From: Michael Eastham <Michael.Eastham@arun.gov.uk>
Sent: 18 November 2020 12:22
To: Planning.Responses <Planning.Responses@arun.gov.uk>
Subject: FW: Y/131/20/DOC - Land South of Ford Lane east of North End Road, Yapton

Please upload onto Ocella the email trail below and the attachments from the applicant to discharge of condition application **Y/131/20/DOC** relating to Land South of Ford Lane and East of North End Road, Yapton.

From: Michael Eastham <Michael.Eastham@arun.gov.uk>
Sent: 17 November 2020 13:41
To: Tilly Whishaw [REDACTED]
Subject: Y/131/20/DOC - Land South of Ford Lane east of North End Road, Yapton

Movement Plan

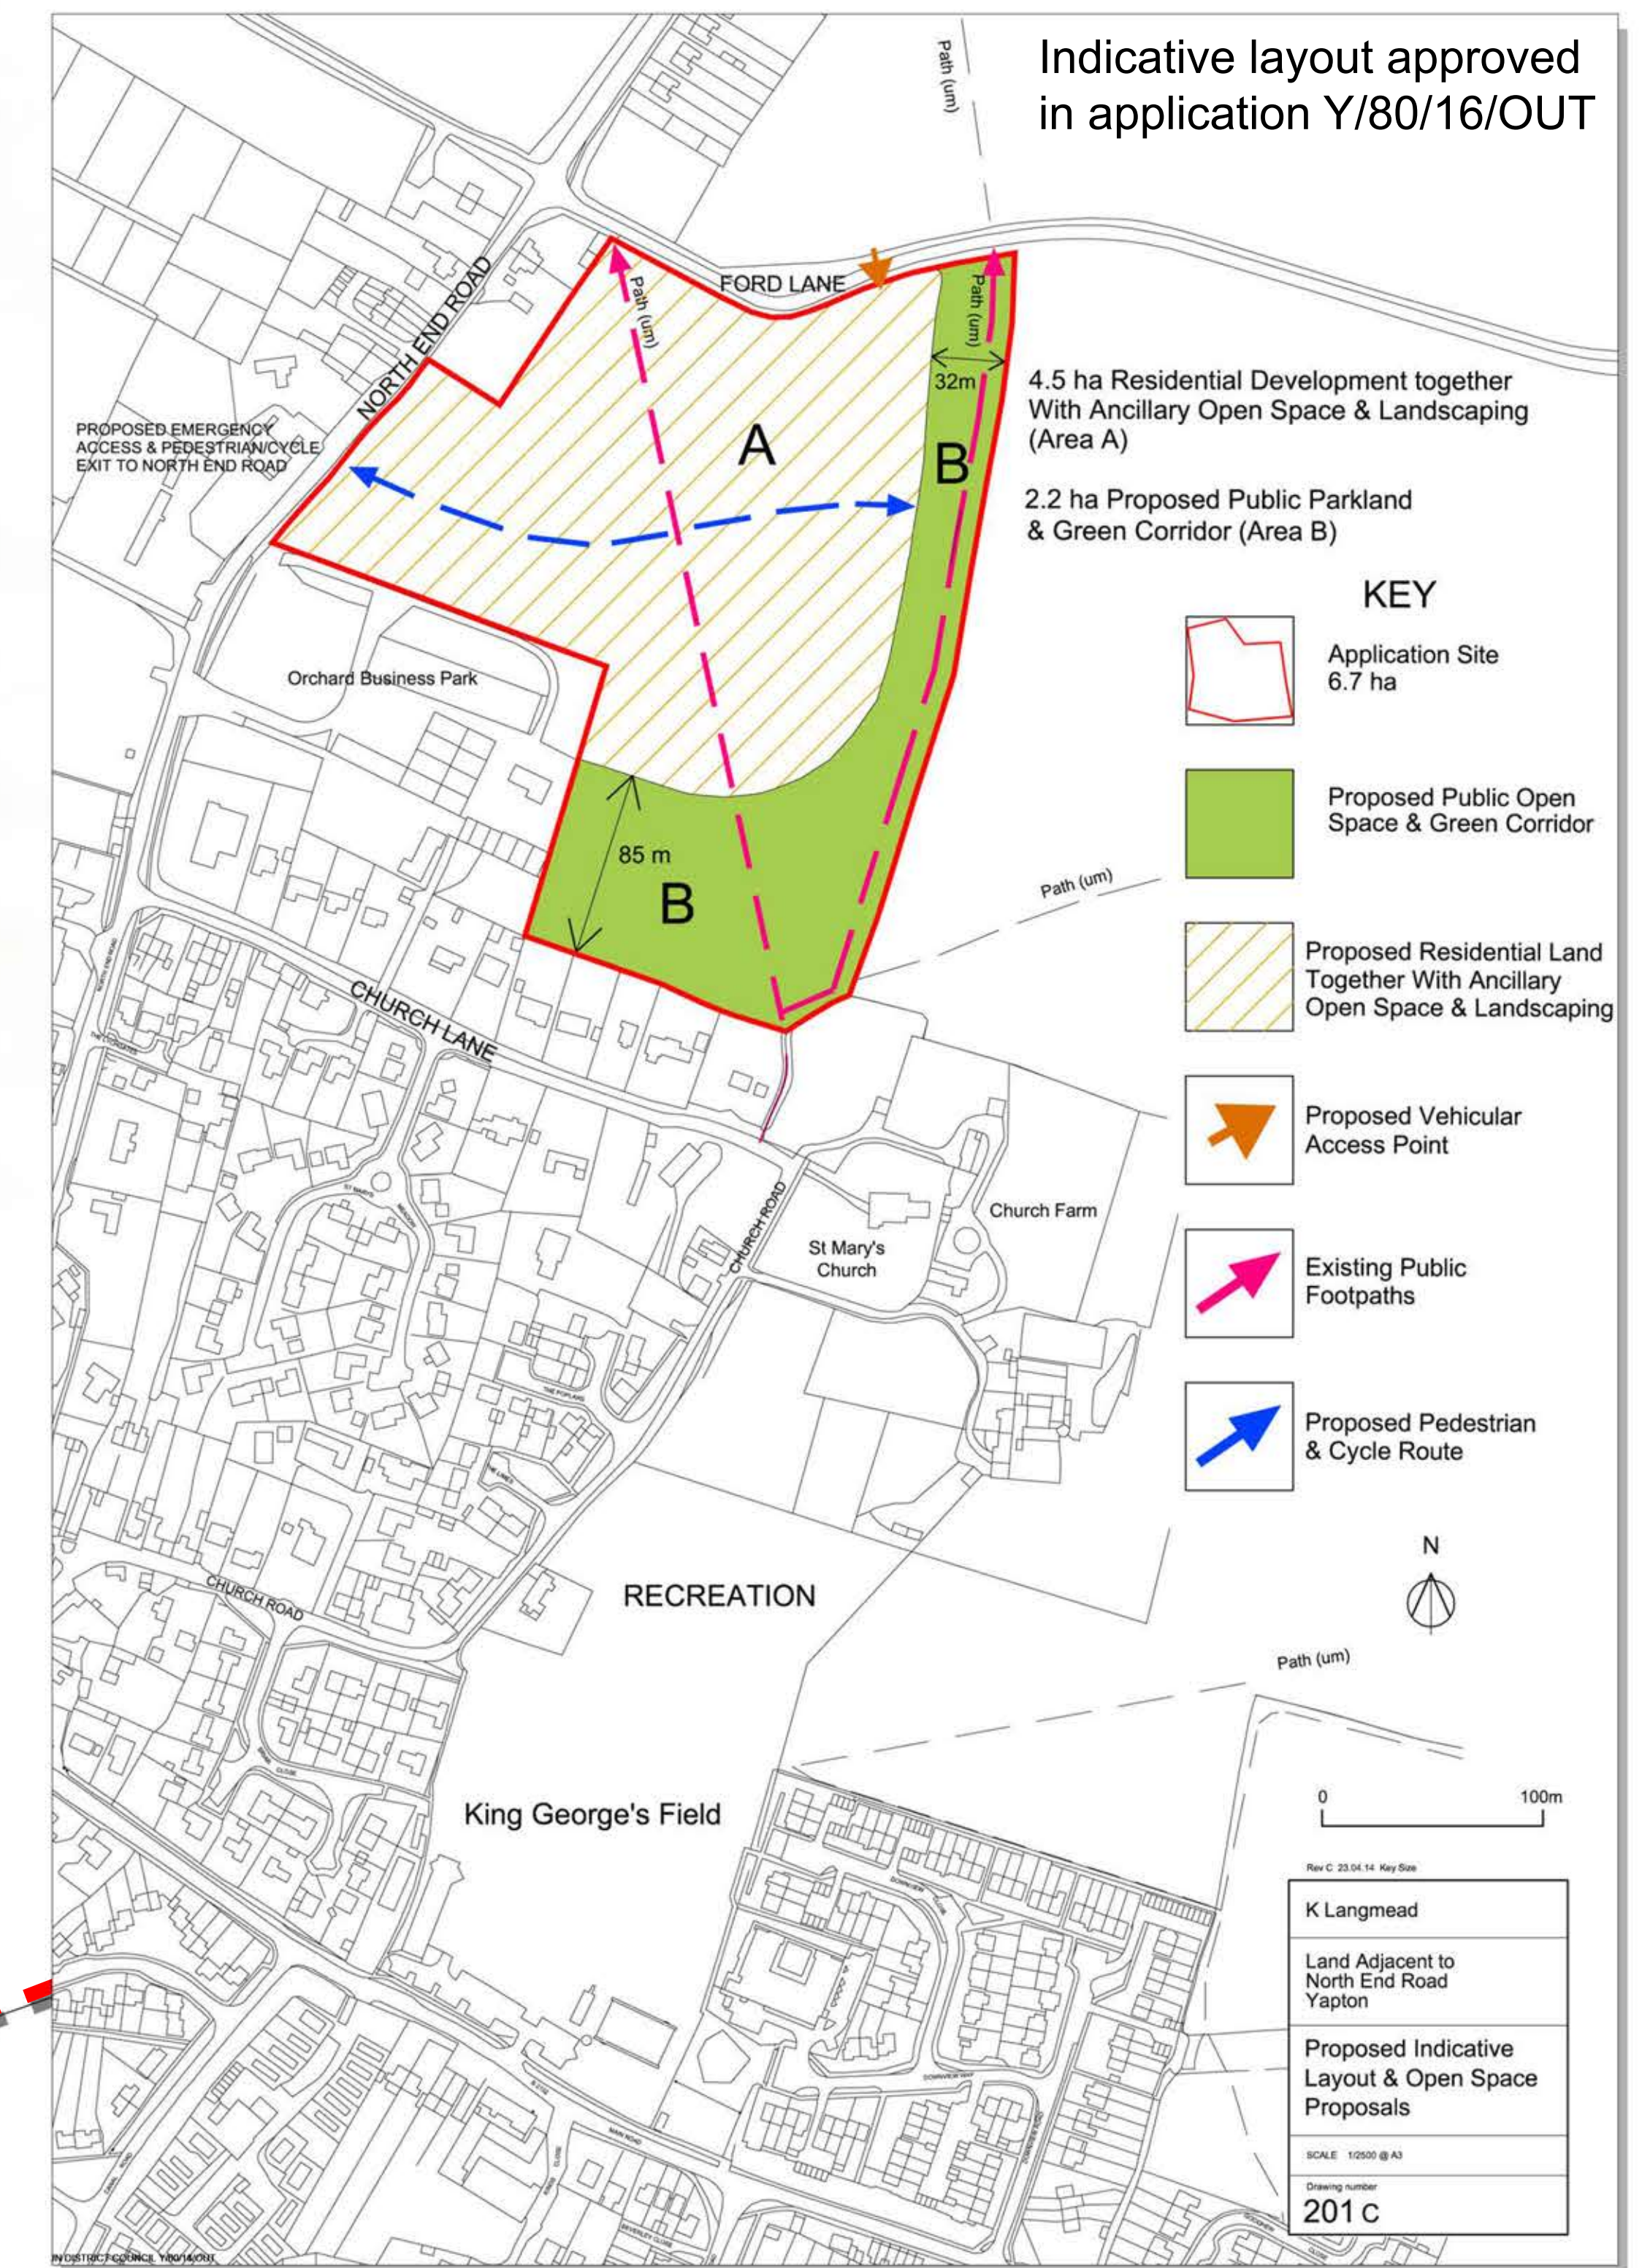
We need to see details of a 3.0 metre wide cycleway running east-west through the site, in accordance with the WSCC guide on cycling.

I was expecting to see a plan showing a cycle way running east / west through the site. Could you submit a revised Cycle plan showing the cycleway running east / west through the site.

Table 2 of the design guide sets out that on residential streets no specific infrastructure is required or necessarily desired, but the roads should be designed with cycle users in mind. On a Spine road, where the road serves a development of greater than 500 dwellings, stepped cycle tracks should be provided throughout on both sides of the carriageway. This information suggests that the two drawings submitted in relation to the cycleway are acceptable for the discharge of the condition, in accordance with the Design Guide, and show that the cycle route has been design appropriately to minimise the speed of traffic. There is therefore no need to widen the road or pavement to provide a separate cycle route.

A 3m cycleway has been provided as required, providing cycle access off North End Road into the site. From this point the cycle way enters the residential street.
